**Gravesham Borough Council**  
**Lower Thames Crossing**  
**Deadline 9 submission**  
**(IP Ref: 20035747)**

**Deadline 9 (D9)**

*Local Landscape Character Area boundaries of the Kent Downs AONB LCA, West Kent Downs, Sub-areas Cobham and Shorne*

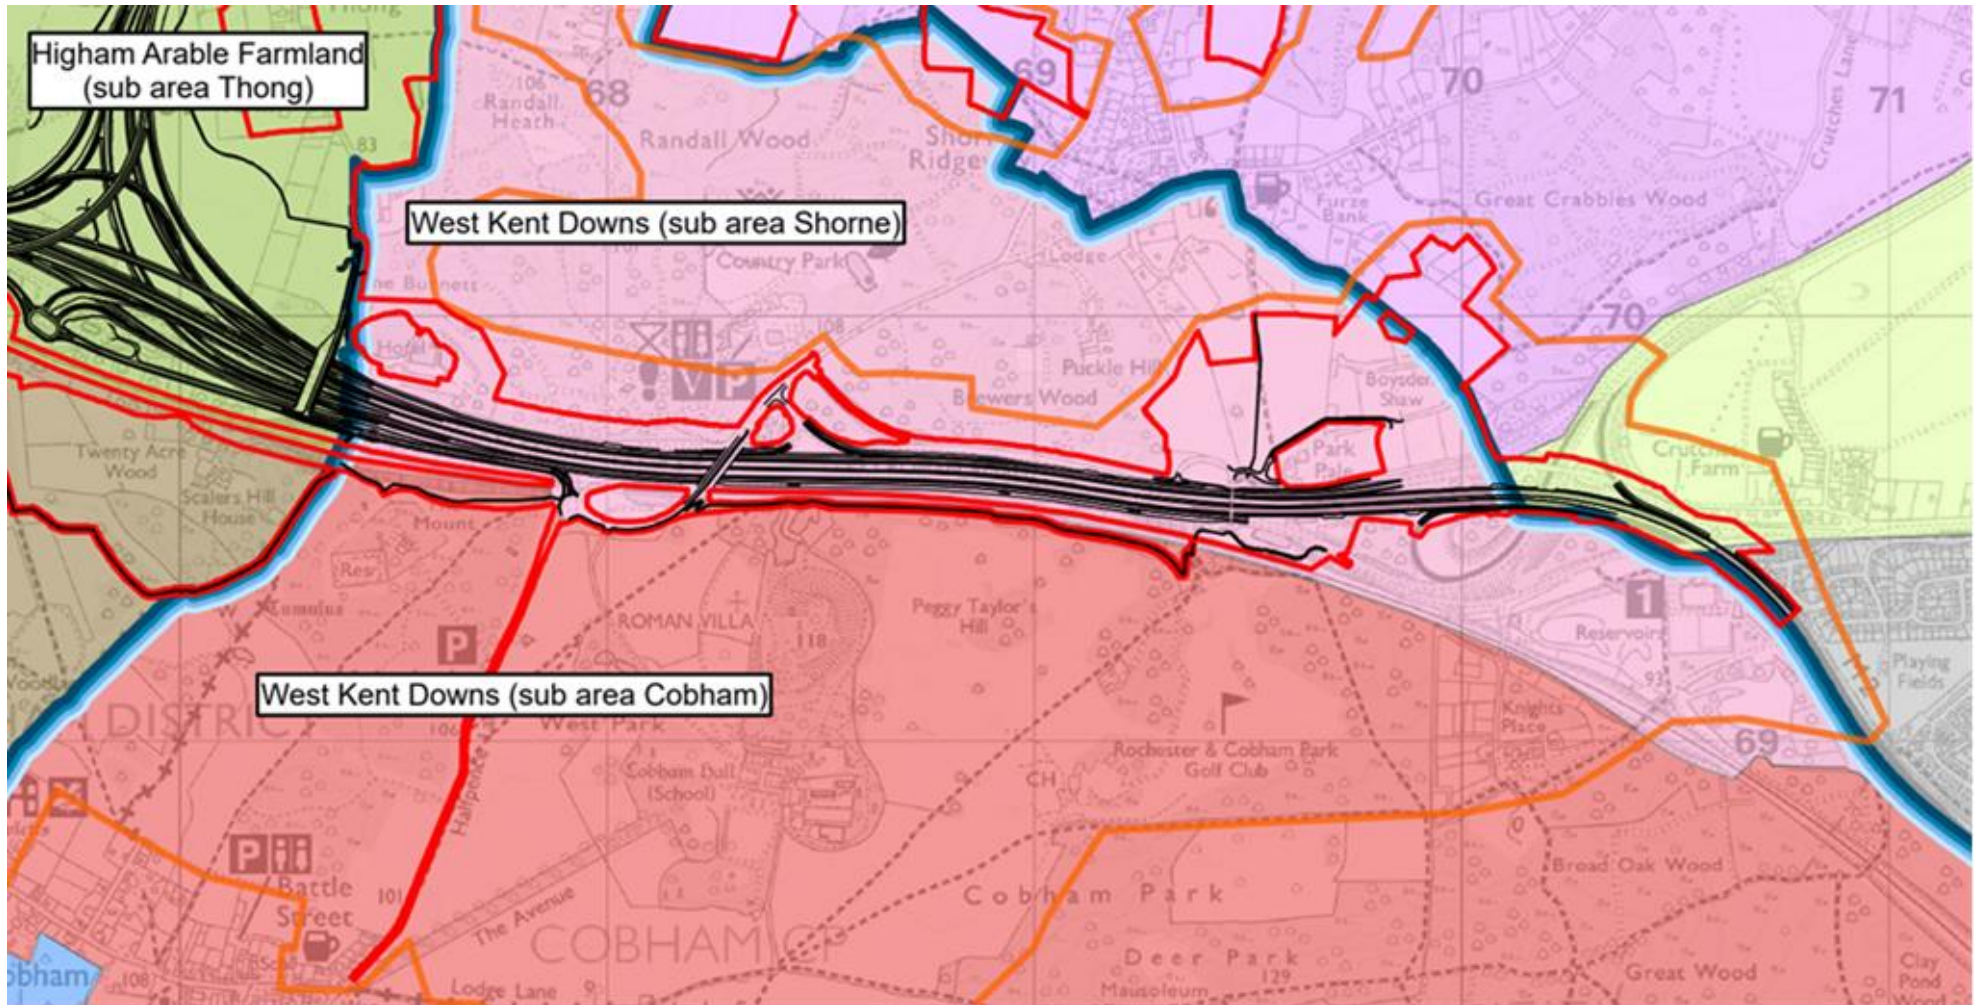
It is GBC's view that the Applicant's response does not support the changes they made to the boundary between the Shorne sub-area and Cobham sub-area LLCAs in their 2020 and 2022 assessments.

The Applicant changed the boundary between the LLCAs for their 2020 LVIA, and it is clear that the change in boundary position influenced the landscape Sensitivity and Magnitude of effect of the proposals on these areas, and thus altered the findings of the landscape assessment of these two LLCAs.

In their post-event submission for ISH11 (REP8-110) the Applicant now states the reasons for the change in the 2020 LVIA are not known (para A.3.4). This being the case, the Applicant has not in fact provided a coherent explanation for continuing to use the changed boundary (barring one minor further revision).

The Applicant's response then goes on to explain a further change in the boundary made between the assessment of 2020 and 2022. The Applicant's explanation includes the prominence of the HS1 corridor and A2 corridor from the southern fringes of Shorne Woods Country Park as one of the reasons for moving the LLCA boundary. Document 6.2 Environmental Statement – Representative Viewpoints – Winter and Summer Views (1 of 8) at Figure 7.17 Viewpoint S-13 Sheet 3 of 3 clearly shows the significant effect of the wooded central reservation on this area, and its role in forming a strong boundary. It is therefore our view that the LLCA boundary should be reinstated. It is noted that the Applicant has provided a new 'without prejudice' assessment on that basis in Appendix B of REP8-110. This is addressed under Action Point 4.

Re para A.5.8 of REP8-110, and their point about double counting; the central reservation of the A2 forms the northern boundary of the Cobham sub-area LLCA. However, it is a matter of fact that it also runs along the southern boundary of the Shorne sub-area LLCA, and the central reservation does have two sides. Even though it forms the northern boundary of the Cobham LLCA, it cannot be ignored in an assessment of the Shorne LLCA, as it forms an important backdrop and screen.
